Our Reference: DW019/01 Rev1
Your Reference:

Land to east of Salesbury View Wilpshire – Planning Reference 3/2025/0801
Proposed erection of new residential development comprising 80 new homes, including 30% affordable housing, open space and associated infrastructure.
Technical Review – Highways and Drainage/Flood Risk

Drawing Title
**DRAINAGE LAYOUT
SHEET 1**

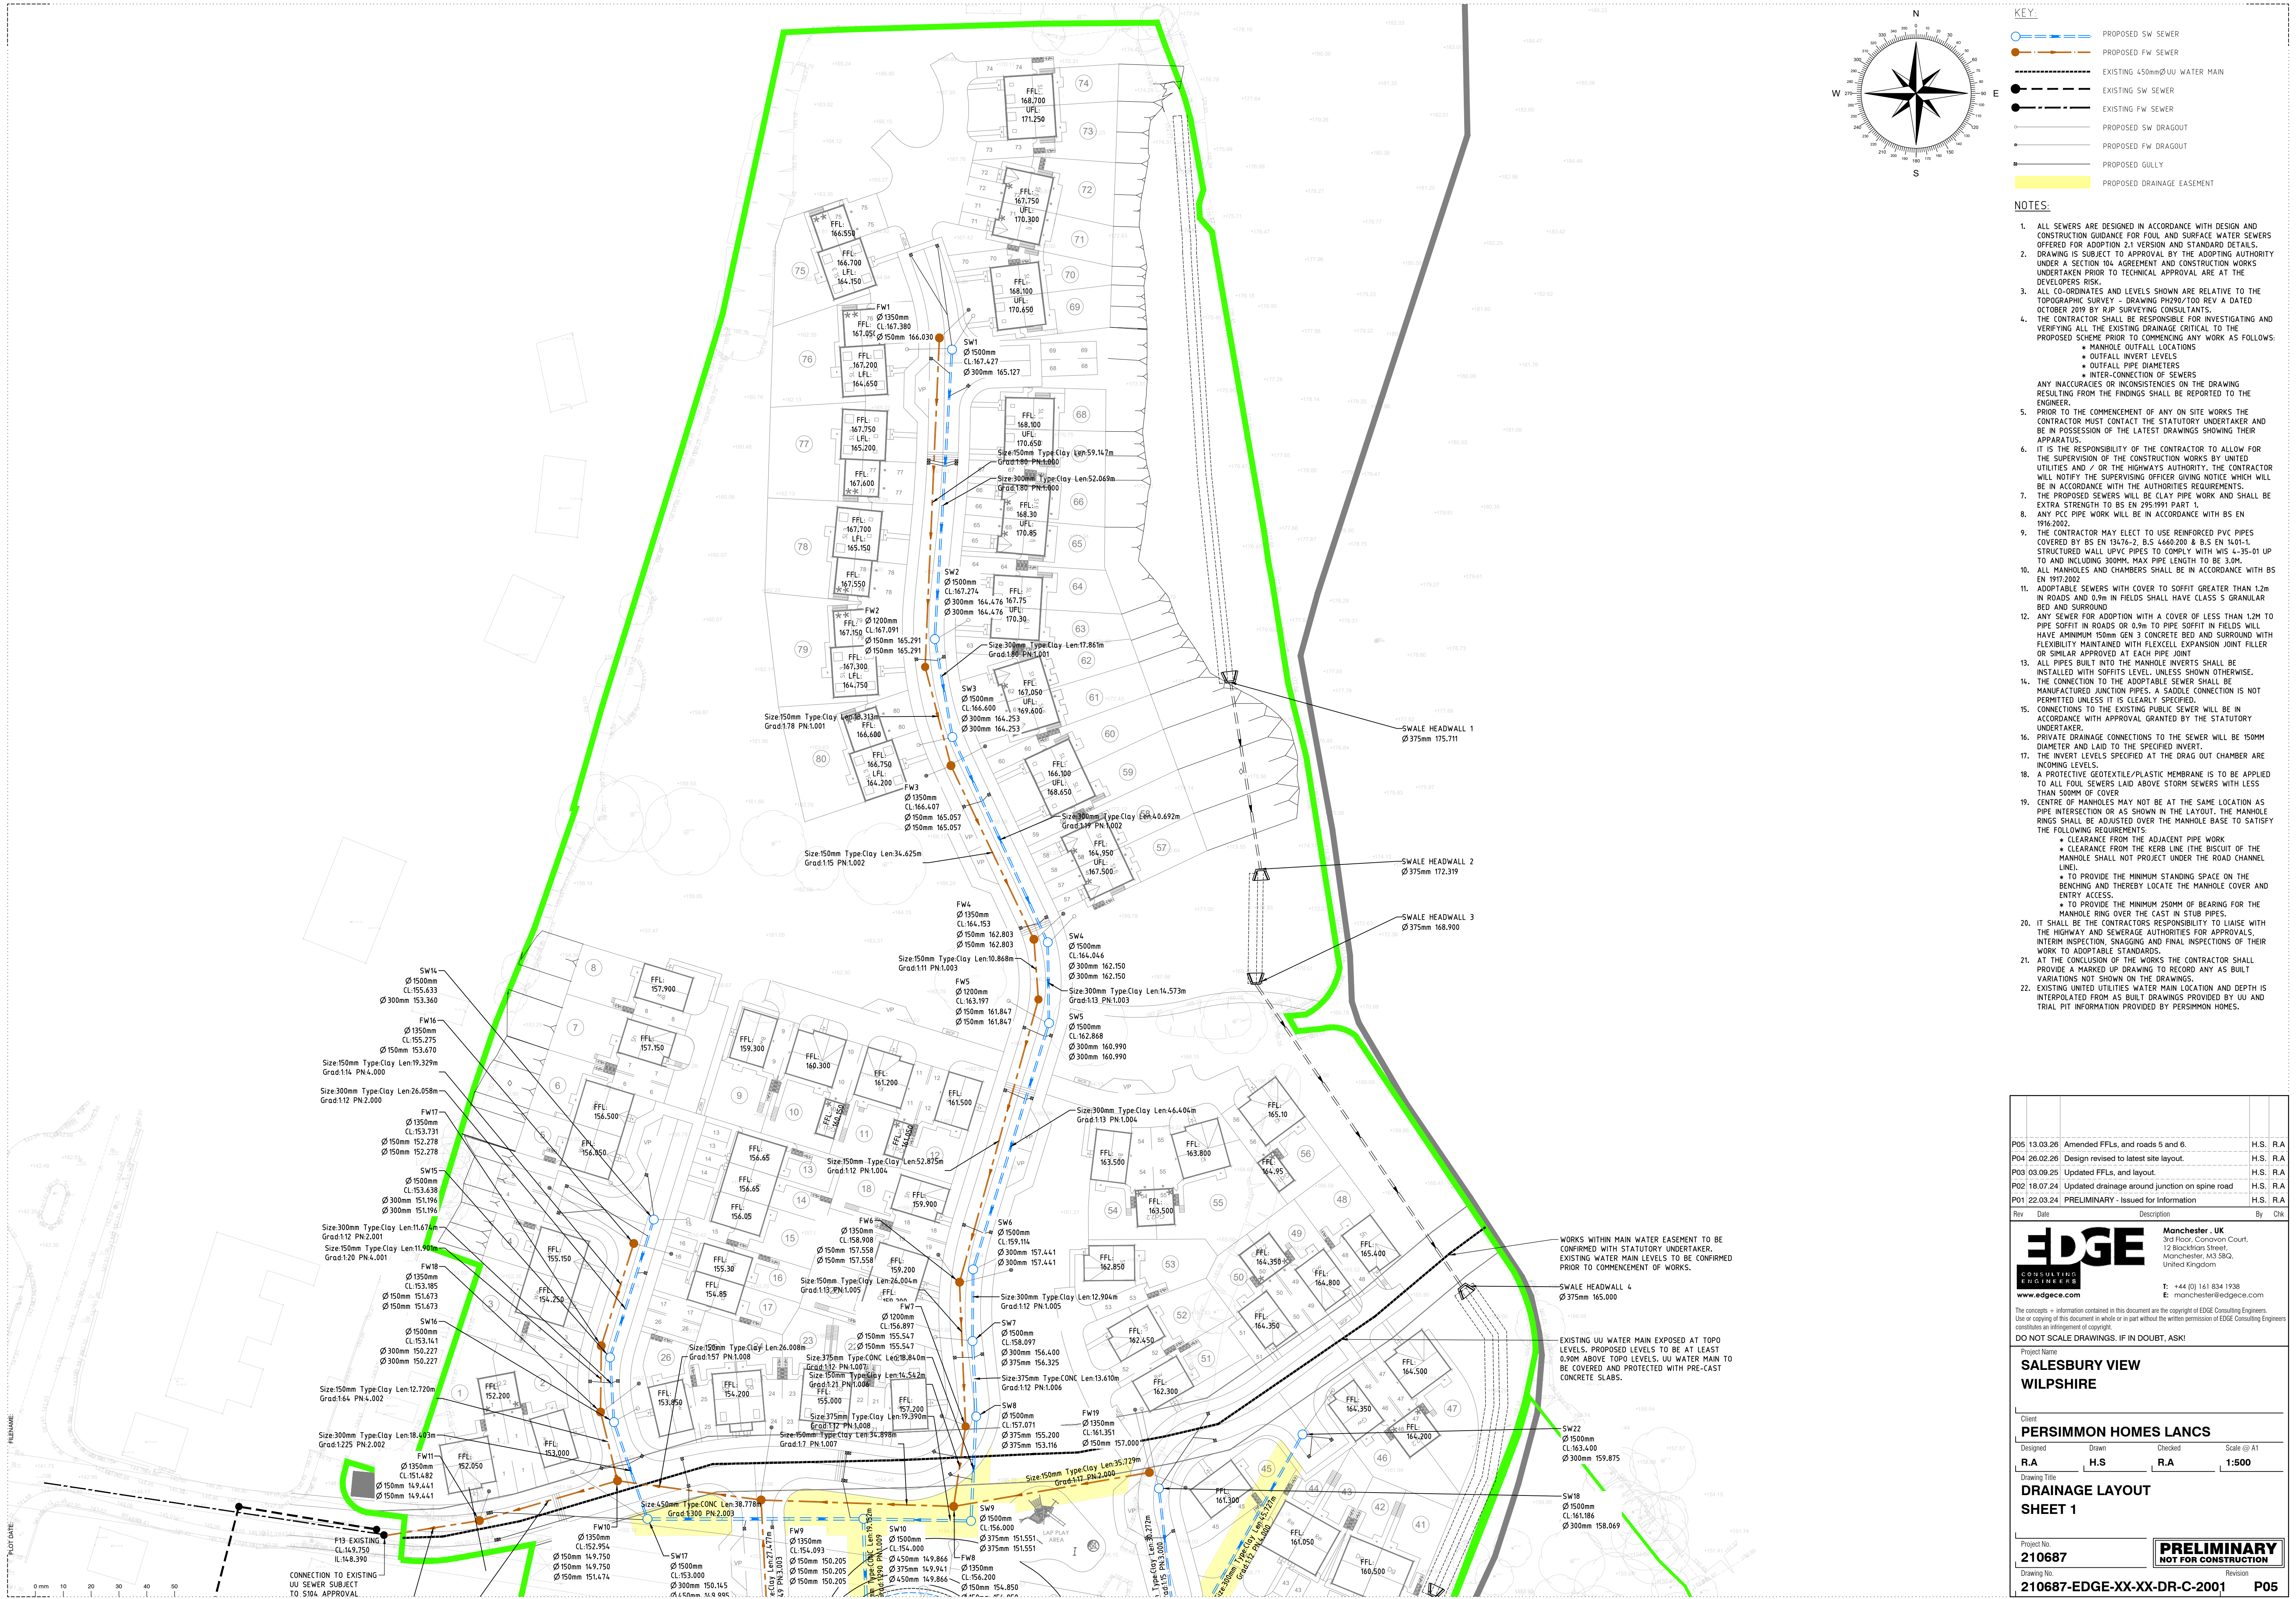
This appears to refer to a response letter from Edge Consulting Engineers, and we would expect reference should rather be made to the FRA (210687-EDGE-XX-XX-RP-C-0001_FLOOD RISK ASSESSMENT[P12]) together with the supporting Drainage Drawings (210687-EDGE-XX-XX-DR-C-2001 and 2002 (P05)

- It does not yet appear that sectional drawings showing the proposed clearance between the water main on site and the proposed drainage has been submitted

I have reviewed of the water main records (submitted) in tandem with the proposed outline drainage proposals. Whilst I agree details have not been specifically assessed, I do not believe that any conflicts between the proposed drainage pipes and the water main would be unsurmountable. Reference to UU guidelines *“Working near our pipes - United Utilities’* provides minimum offset distances for their apparatus. Such is the topography of the site, even if clashes were apparent based on the outline proposal, there would very likely be tolerance to lower or raise the drainage pipe to provide suitable clearance.

Project No. 210687	PRELIMINARY NOT FOR CONSTRUCTION
Drawing No. 210687-EDGE-XX-XX-DR-C-1002	
	Revision P03

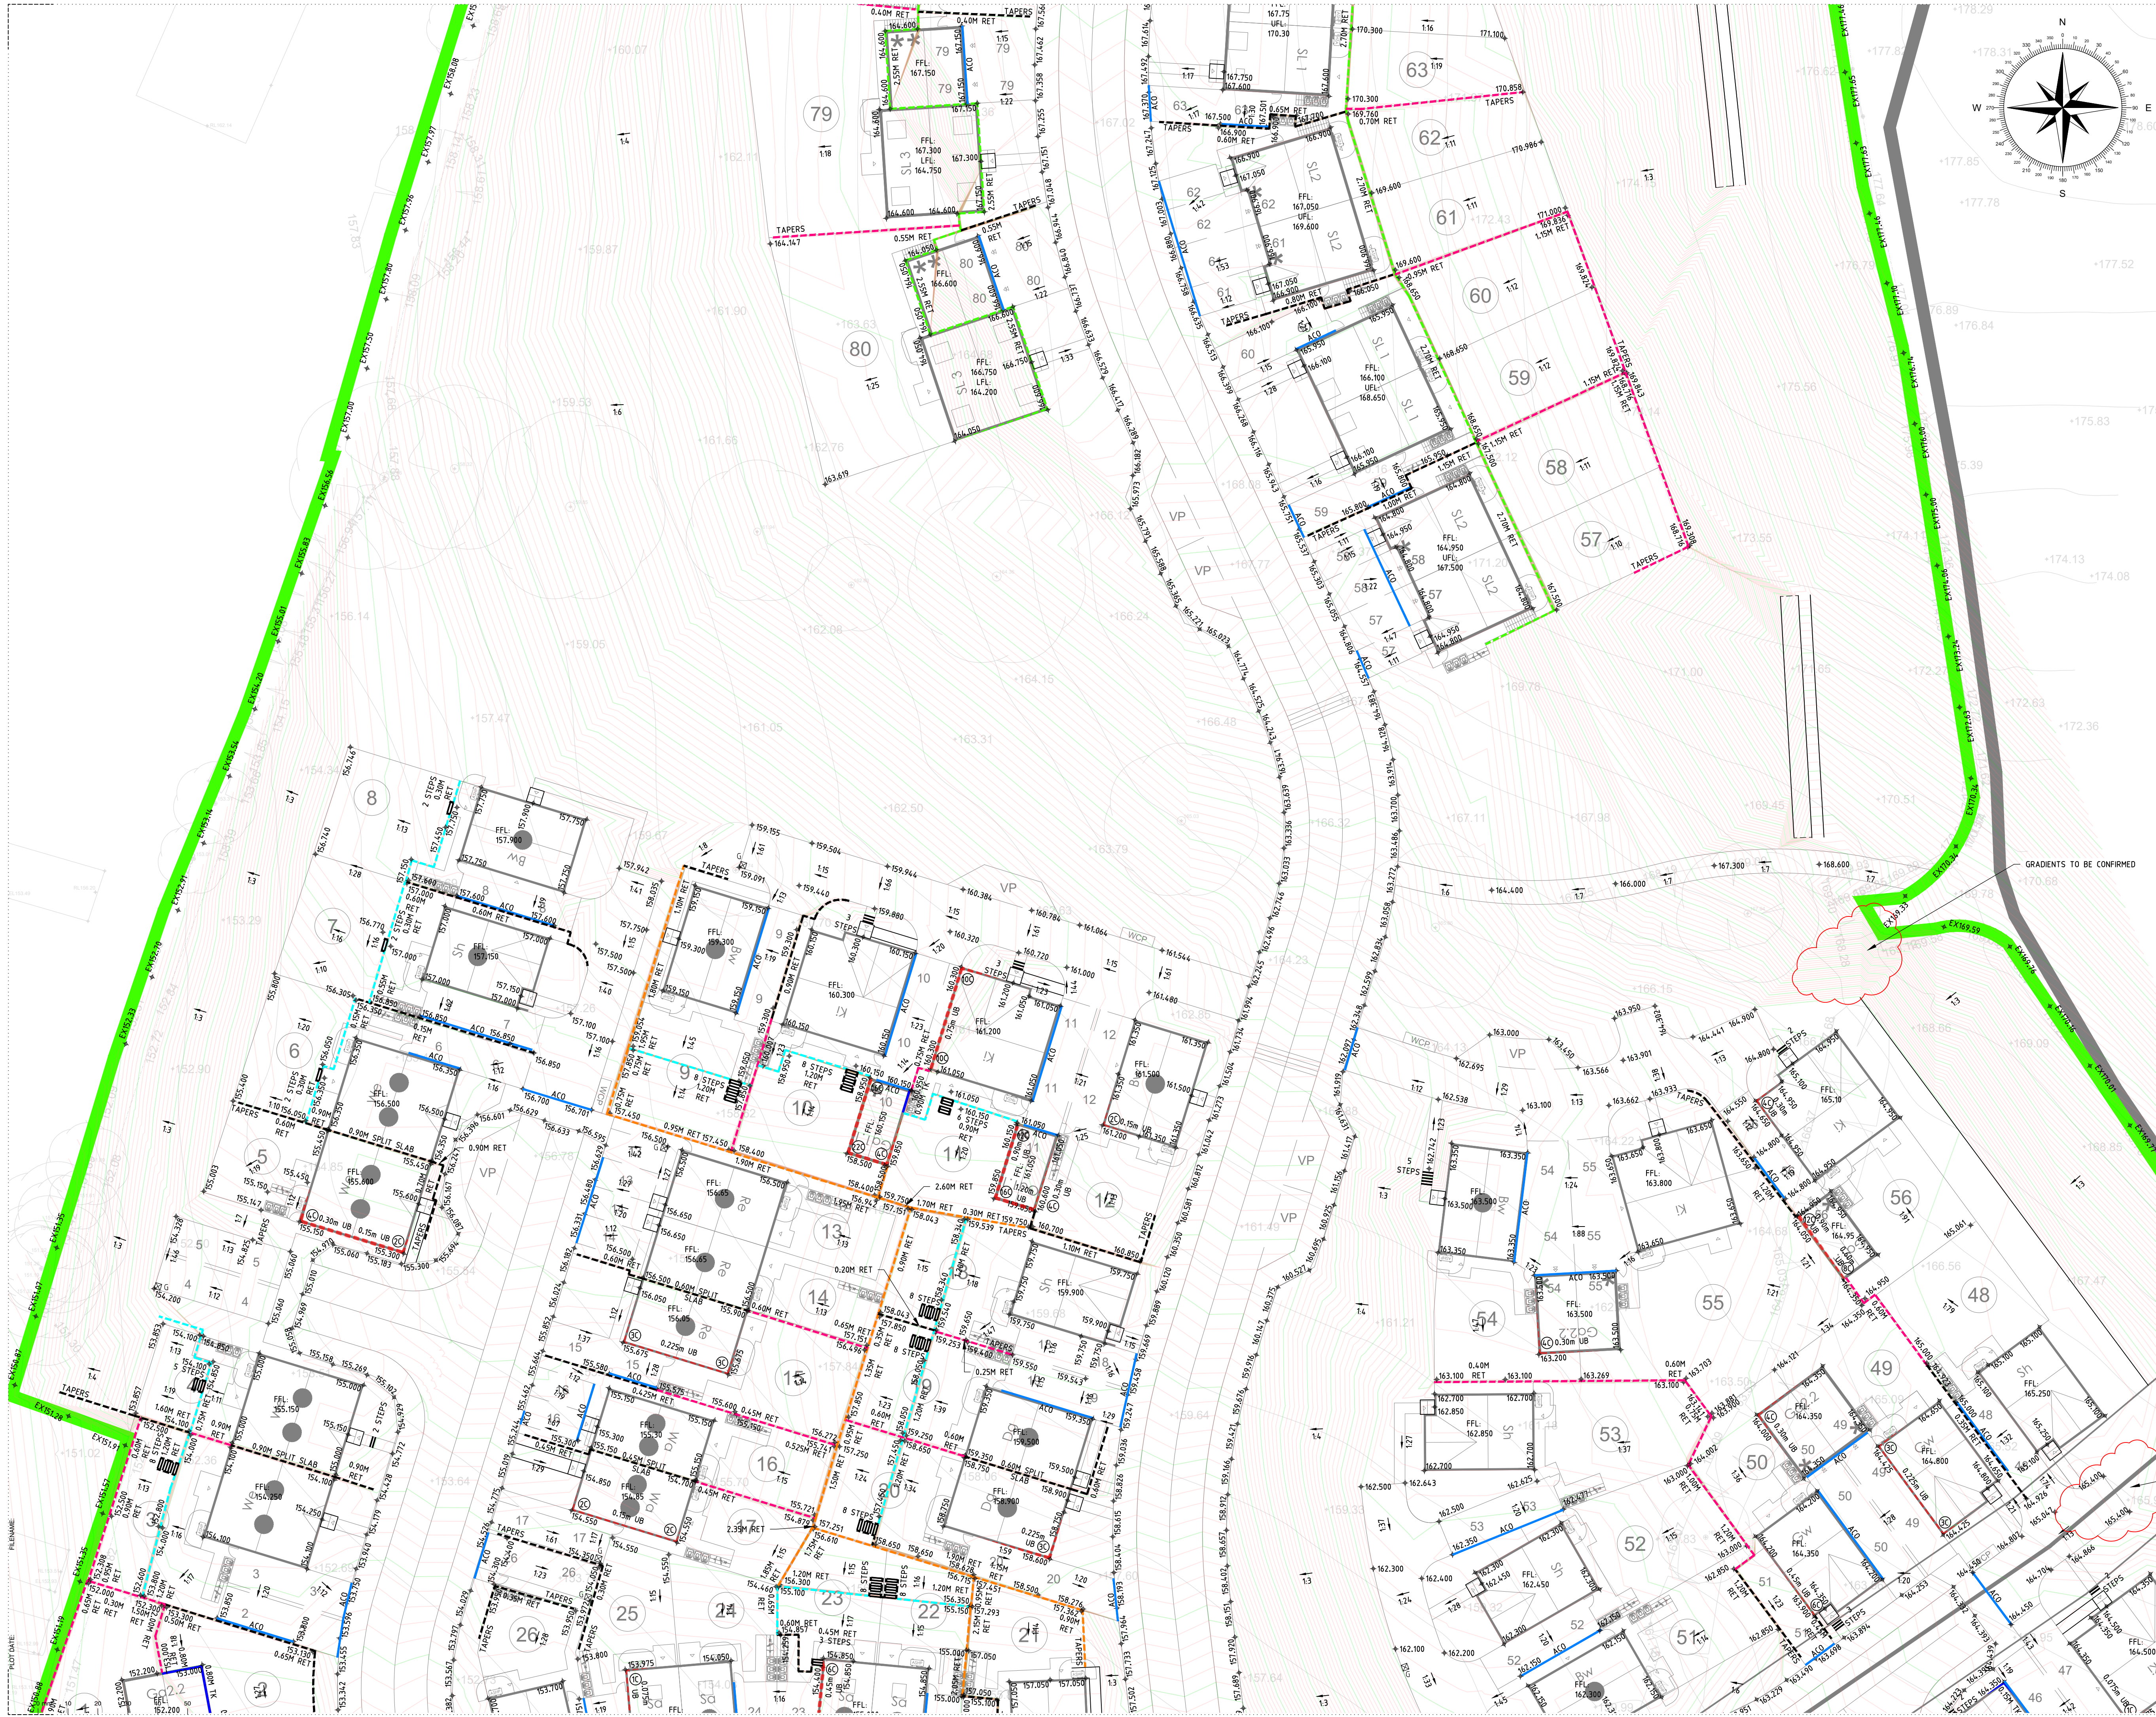
- Finished Floor Levels are 150mm or less from the drainage cover levels

Edge Consulting External Works Plans (210687-EDGE-XX-XX-DR-C-1001 to 1005) clearly show FFLs raised 150mm above surrounding ground levels. Recommended Planning Condition 01(b) also makes specific reference to FFLs being 150mm above ground levels and required site plans showing detailed flood exceedance routes, therefore addressing this issue.
